Consultation Response from KC, Highways Development Management
2026/91615 Land off, Roslyn Avenue, Netherton, Huddersfield, HD4 7EW
Discharge of details reserved by Conditions 14 (Phasing Plan), 15 (Construction Ecological Management Plan (CEMP)), 16 (Construction Environmental Management Plan: Biodiversity), 17 (Phase 2 Investigation), 18 (Remediation Strategy), 19 (unexpected contamination), 20 (verification), 21 (Surface water drainage scheme), 22 (Flood routeing), 23 (temporary surface water), 24 (Arboricultural method statement), 25 (road condition survey), 26 (highway structures), 27 (retaining wall spec), 28 (Written Scheme of Archaeological Investigation (WSI)), 29 (Ecological Design Strategy (EDS)), 30 (PROW HUD/228/10 improvement spec), 31 (road, footway, and footpath spec), 32 (site access spec), 33 (internal estate streets spec), 34 (Local Equipped Area of Play (LEAP) spec), 35 (Travel Plan), 36 (Cycle store details), 37 (ancient woodland information boards spec), and 38 (ancient woodland information packs spec) on previous permission 2025/91870 for variation of conditions 5 (plans and specifications), 29 (Ecological Design Strategy), 32 (site access works and road mark

DRAWING No.	REVISION
11676-HBL-XX-XX-DR-C-5480	P01

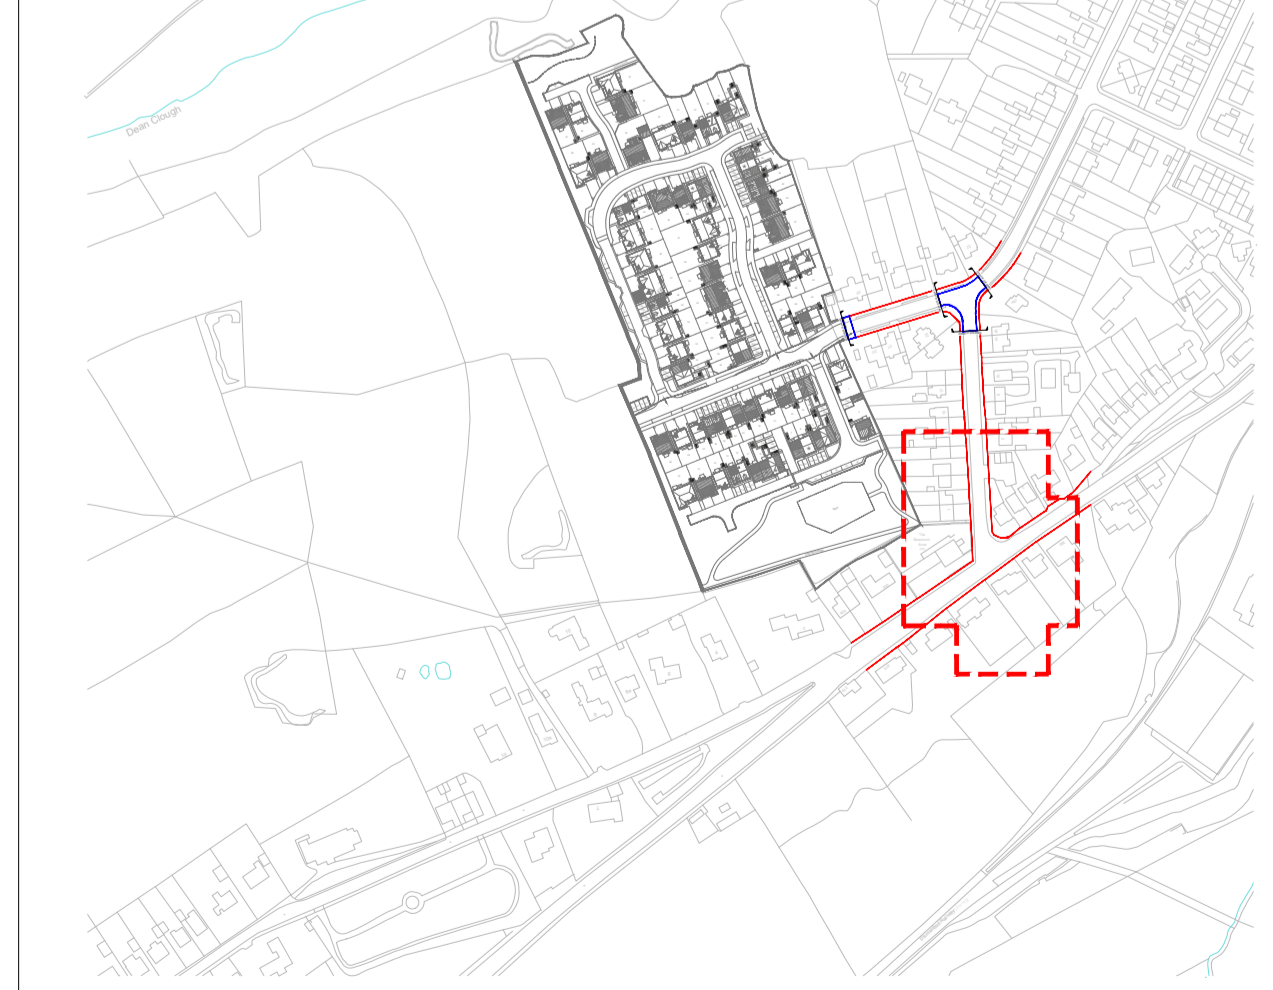
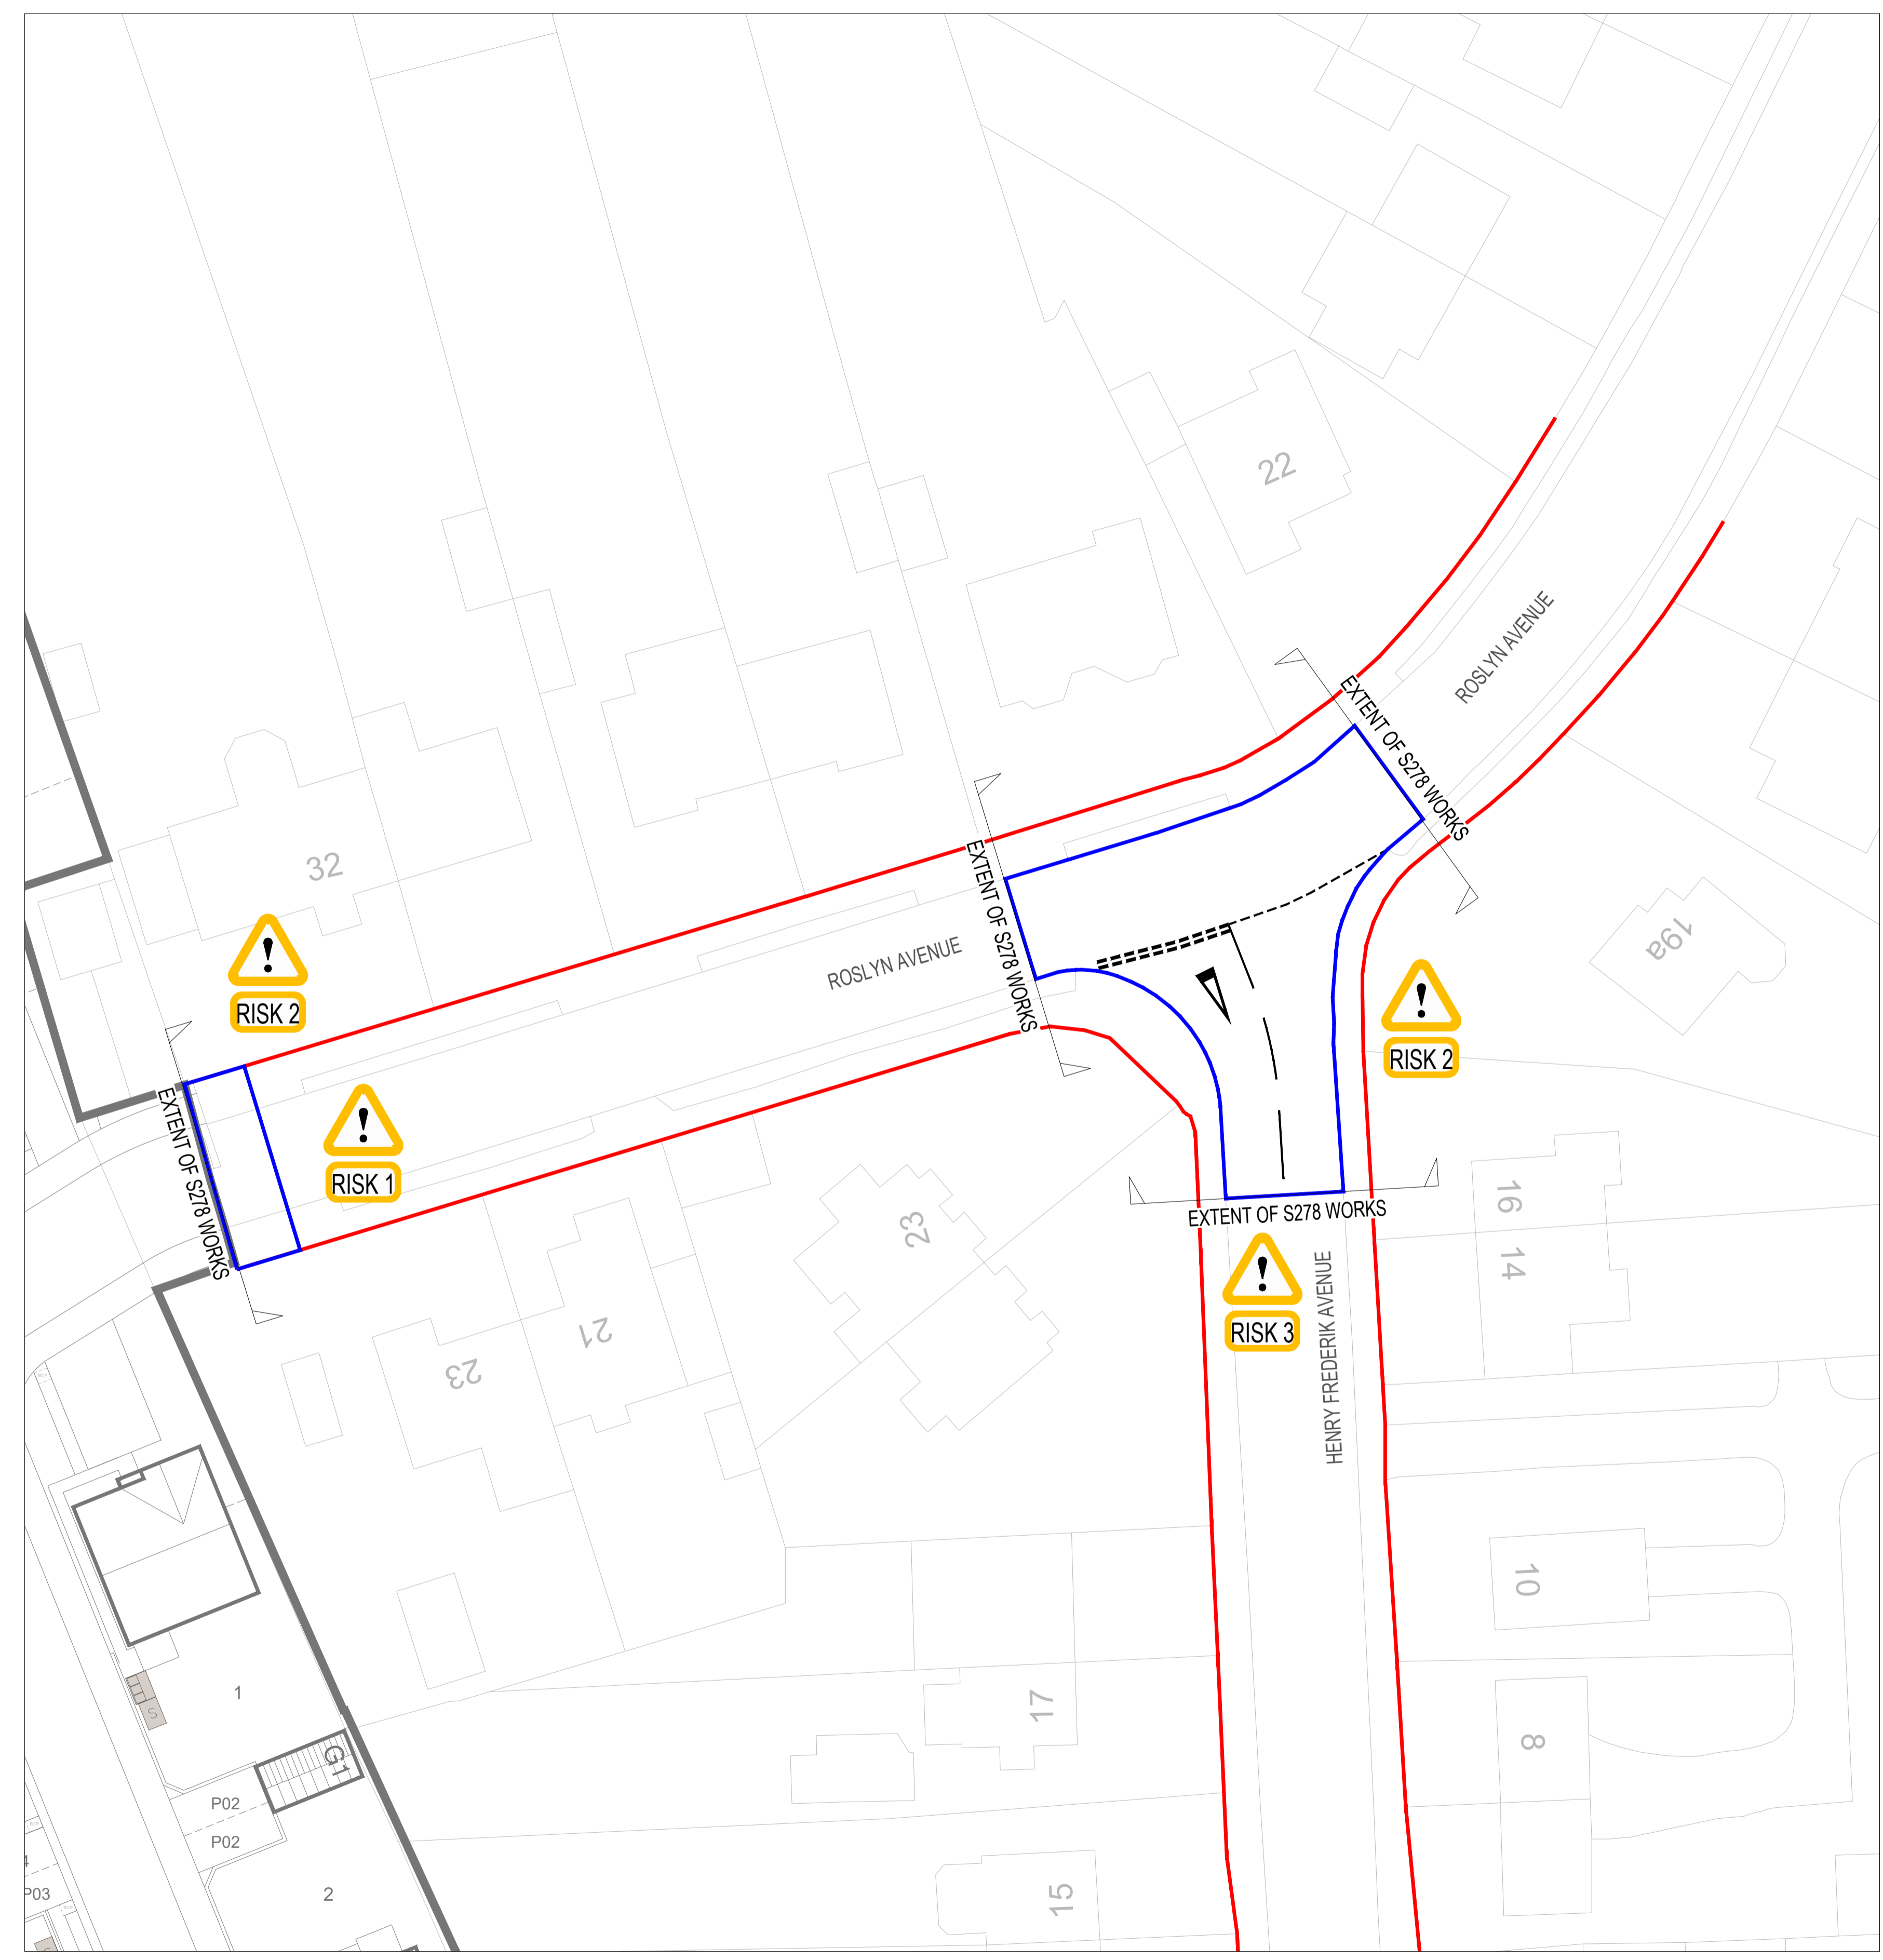
A Section 278 package of drawings has been submitted. This includes the Section 278 Agreement Plan (Drawing Ref: 11676-HBL-XX-XX DR-C-5401 Rev. P01), Section 278 Arrangement Plan (Drawing Ref: 11676-HBL-XX-XX-DR C-5402 Rev. P01), Kerbing, White Lining and Signing Plan (Drawing Ref: 11676-HBL-XX-XX DR-C-5403 Rev. P01), Construction Details Sheet 1 (Drawing Ref: 11676-HBL-XX-XX-DR-C5461 Rev. P01), Construction Details Sheet 2 (Drawing Ref: 11676-HBL-XX-XX-DR-C-5462 Rev. P01) and the Designers Risk Assessment (Drawing Ref: 11676-HBL-XX-XX-DR-C-5480 Rev. P01).

Confirmation is awaited from the Highways Agreements team and further comments will be separately provided, on the officer's return from leave. Again, drawings must be in accordance with planning approval 2025/92541 or a latter revision. Further information is necessary.
